Application for a Non-Material Amendment Following a Grant of Planning Permission

Conversion of existing garage into a bedroom with en-suite to include single storey side extension and pitched roof.

2022/1404/FUL

Correction of height annotated/ specified on proposed drawing.

DRAWING NO. & REVISION
03a

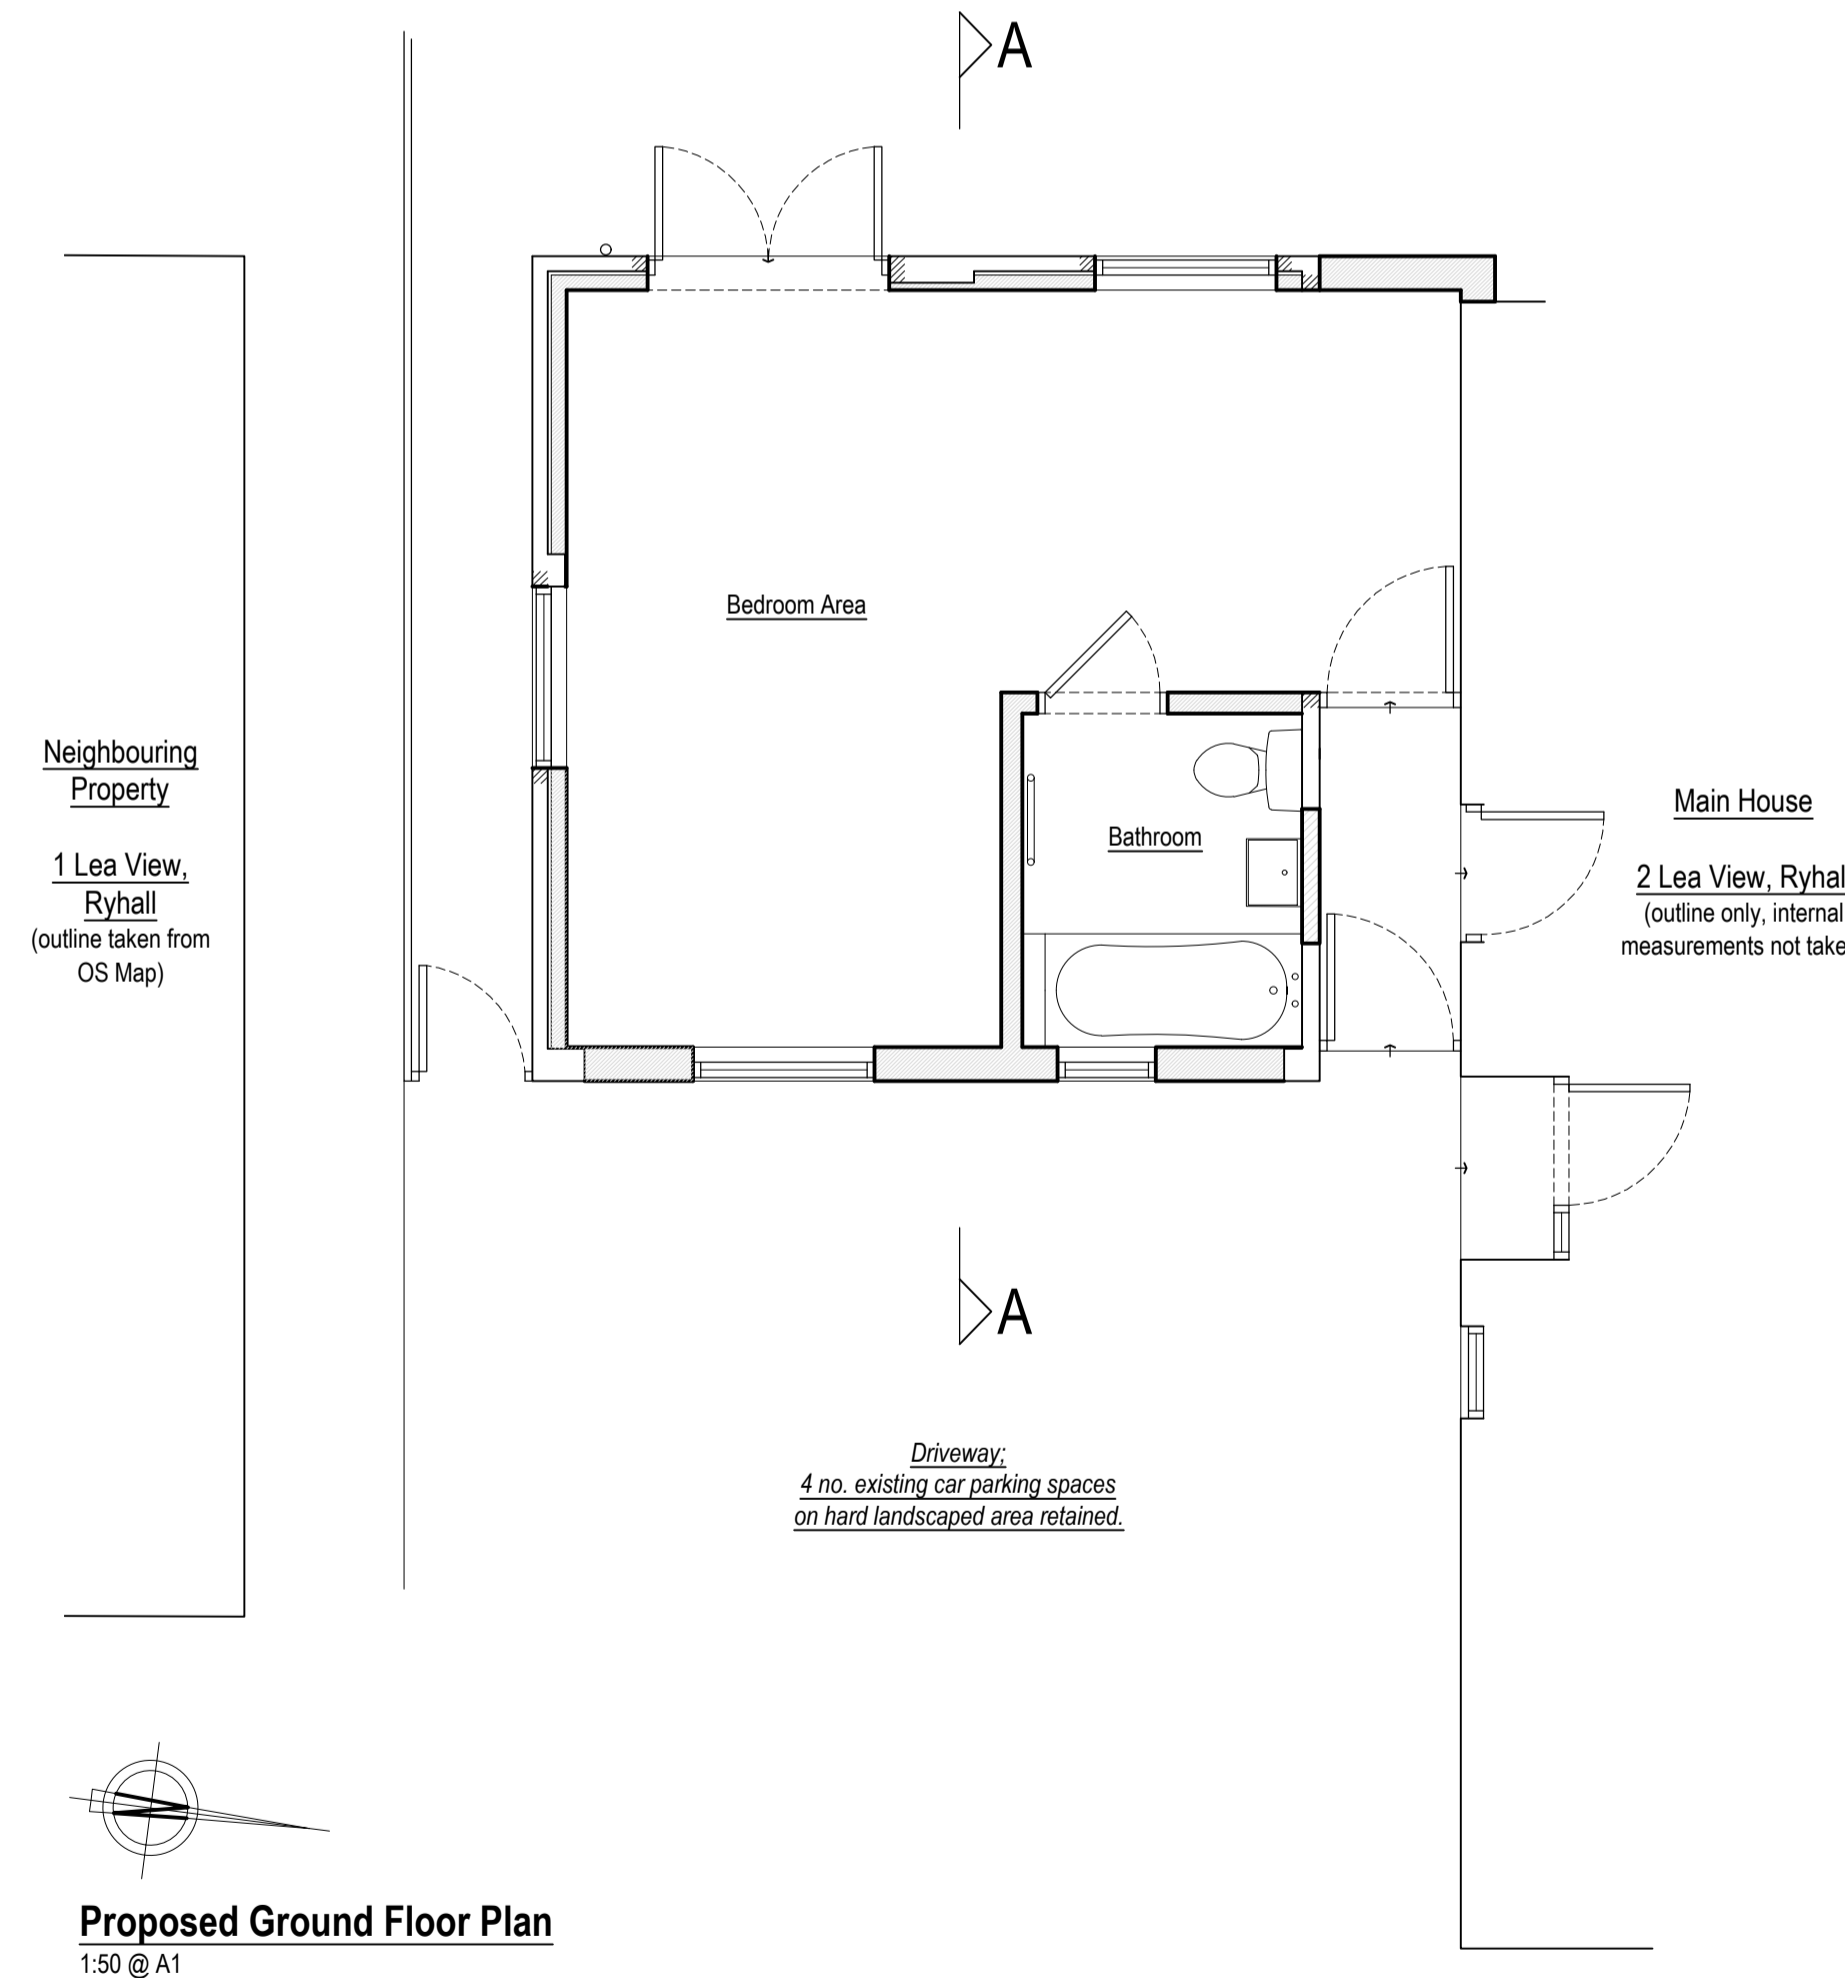
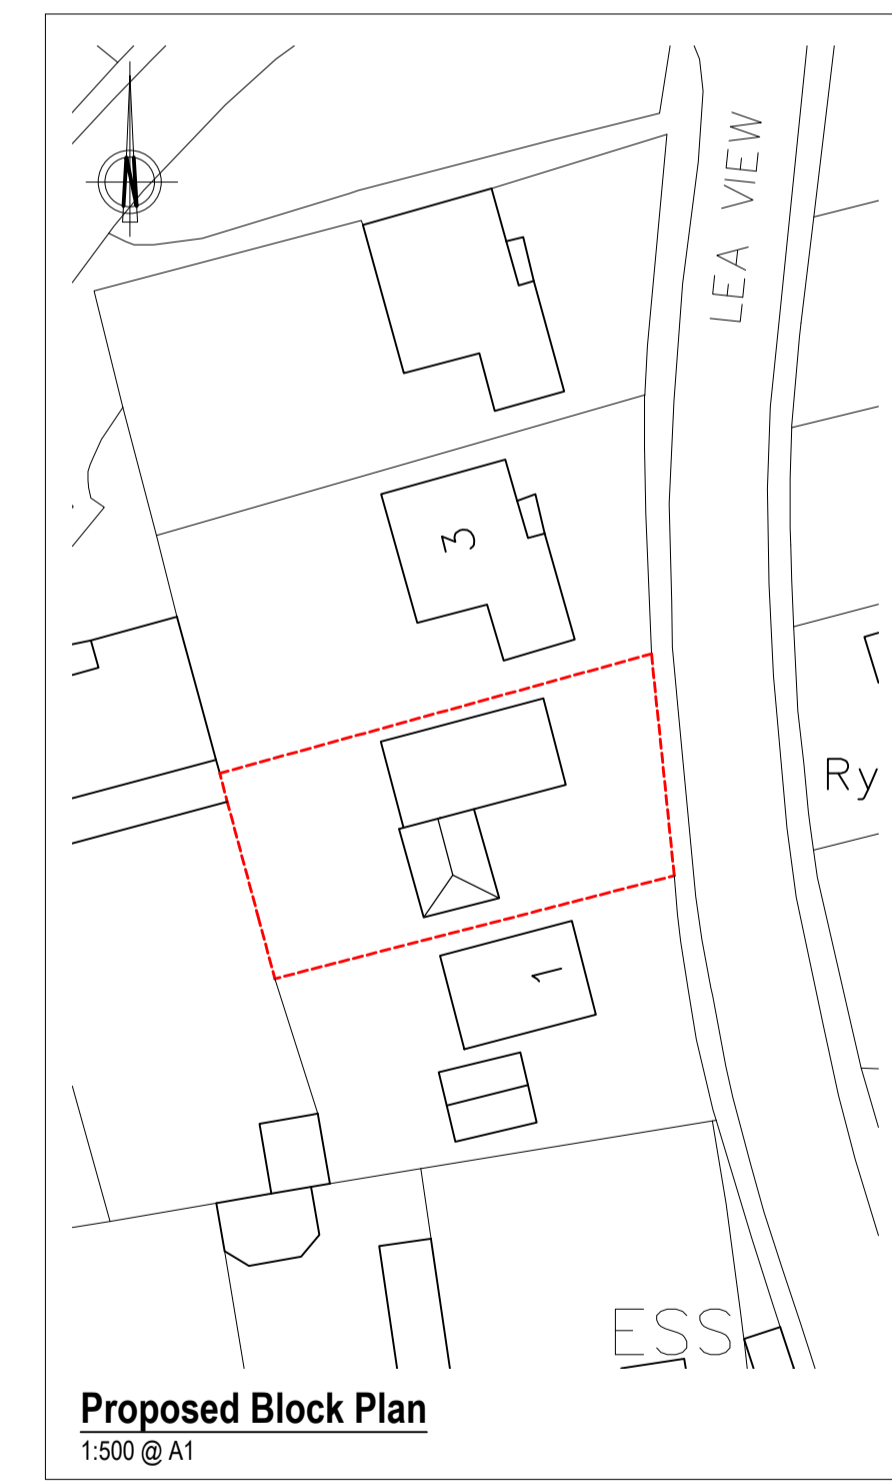
Annotation of height increase was incorrect, however proposed drawing elevations and section are correct.
